From: Zac Denton [REDACTED]
Sent: 18 June 2019 10:56
To: David Bennett
Cc: Juan Baeza
Subject: RE: 2 Hillview Crescent

Further to our recent meeting at the above I have agreed some changes with the applicant and attach Dwg. Nos. 18-111-9, 10 and 11.

DRAWING BY <i>DJB</i>	Scales (original on A1 to crop marks): Elevations 1 : 50
DATE <i>May 2019</i>	
DRAWING No. REV <i>18-111-10 -</i>	 Protected By the Copyright, Designs & Patents ACT 1988

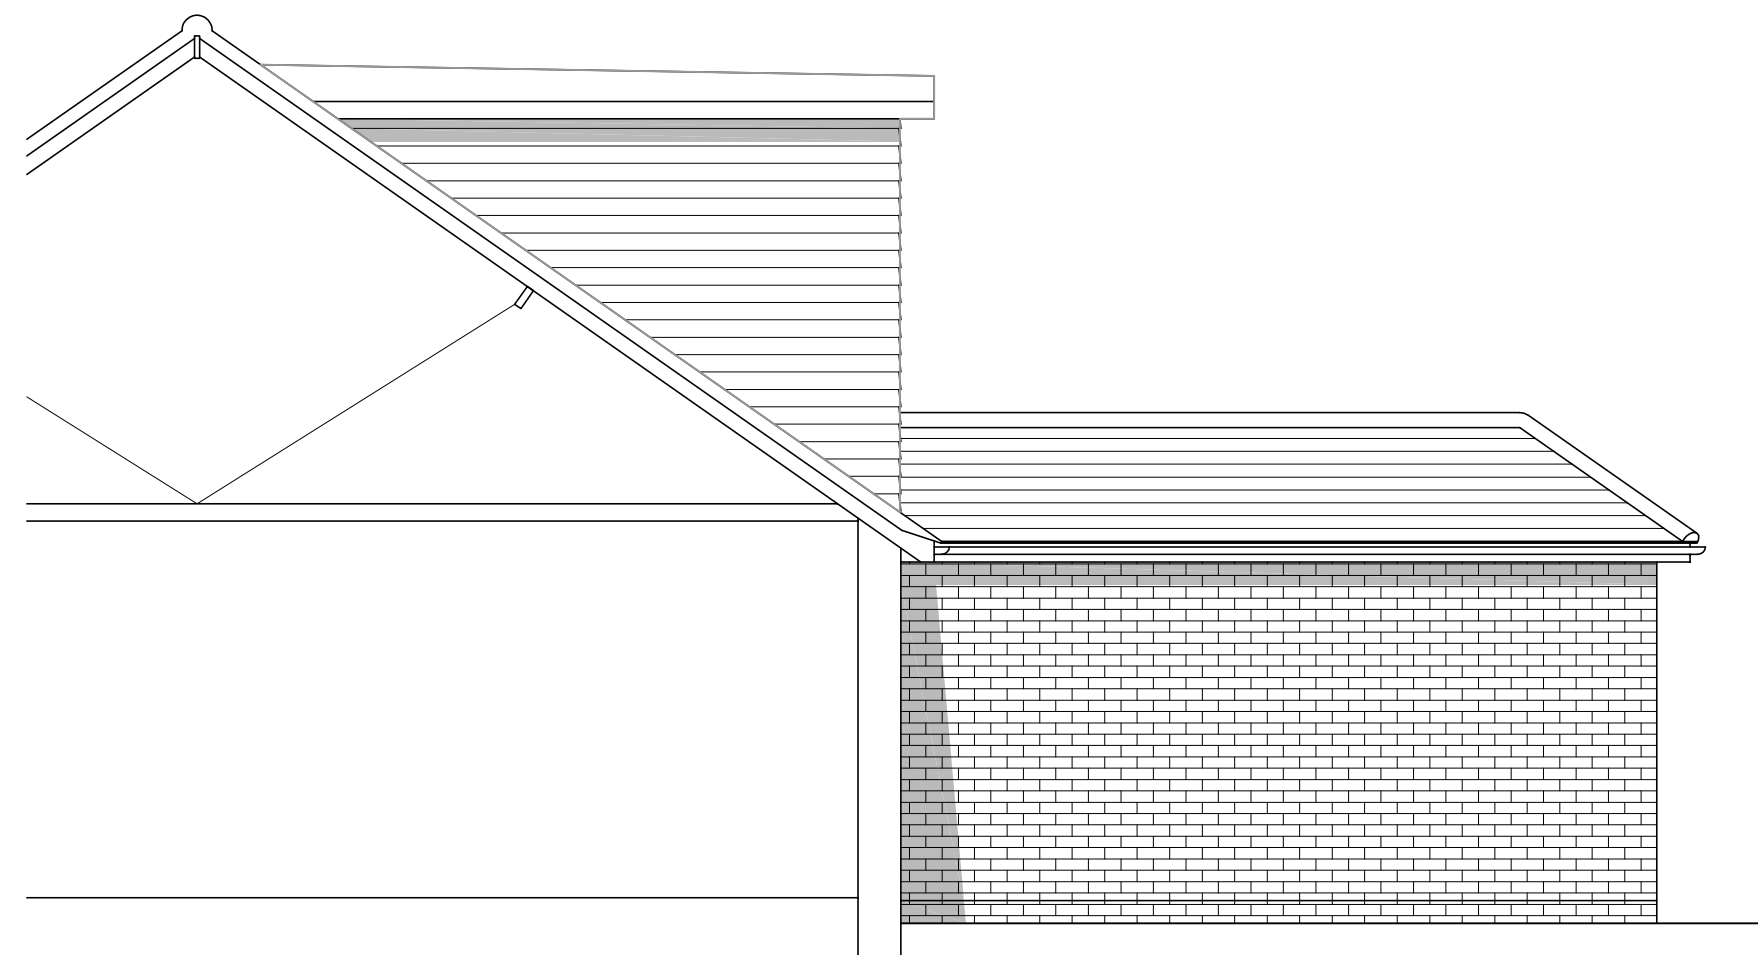
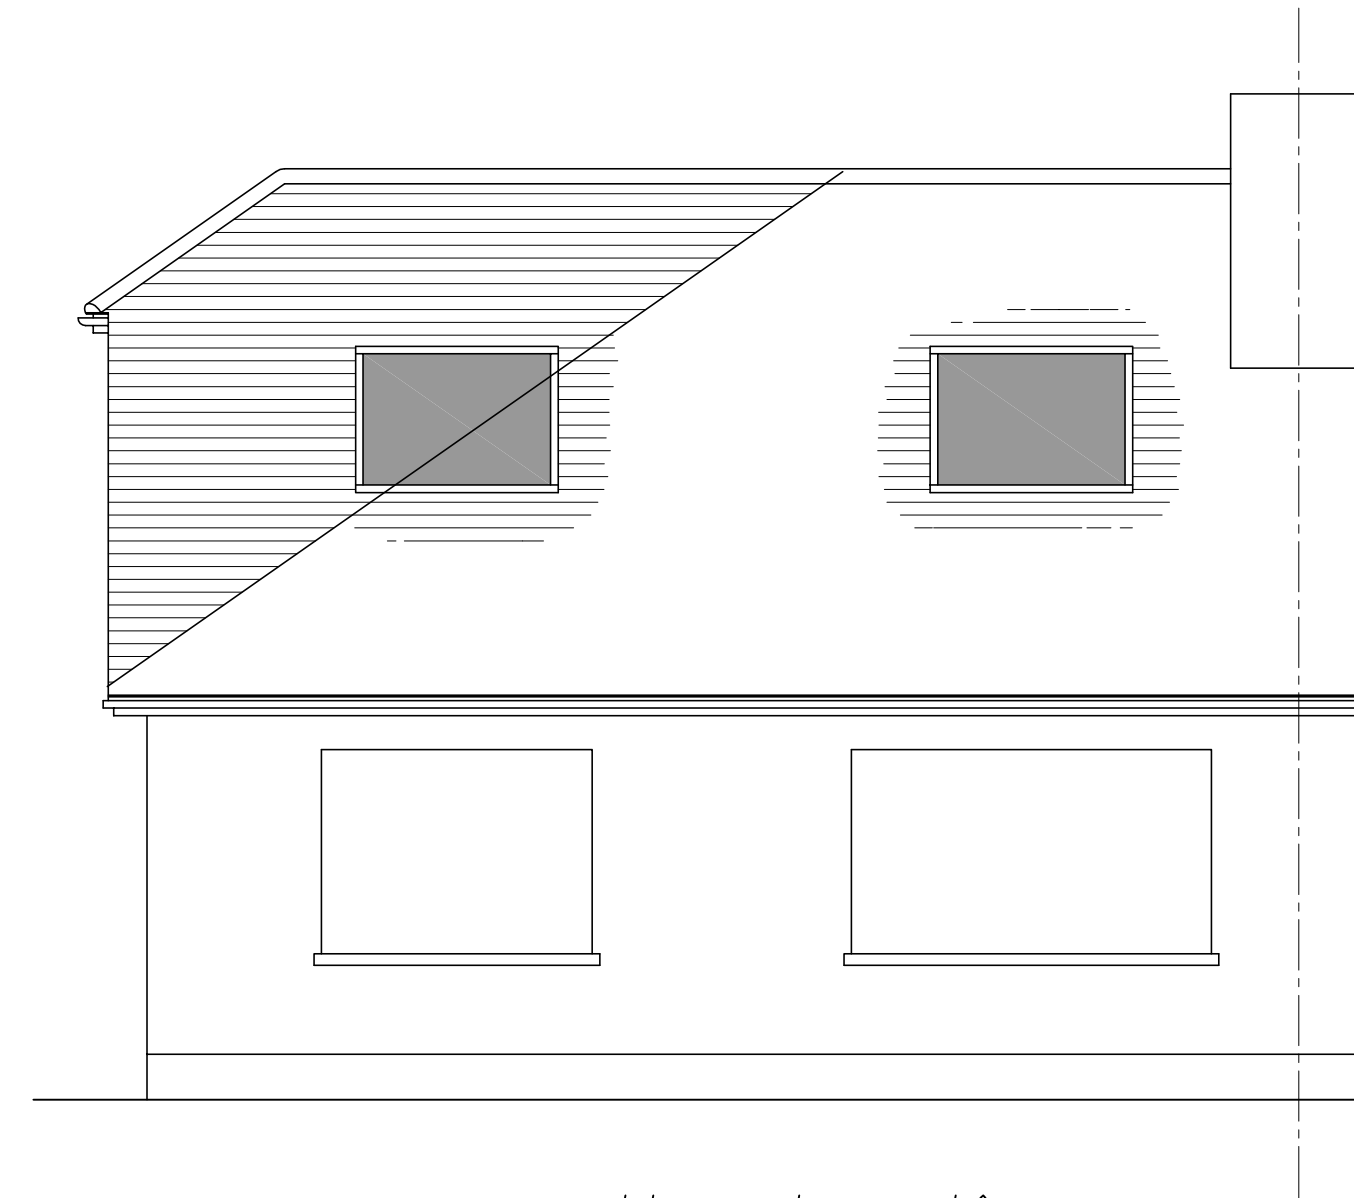
I cannot bring the east dormer cheek any further away from the boundary with 28 Orchard Road as the internal space created here forms the volume / height required for the staircase. We're happy for the bathroom dormer to be obscure glazed and fixed shut to 1.7m.

I have brought the west dormer cheek further away from the west flank but would like to retain a clear glazed openable window in this area.

It would appear that the plans take into account the comments and issues raised previously. On a without prejudice basis, it is recommended that you submit a planning application for said proposal.
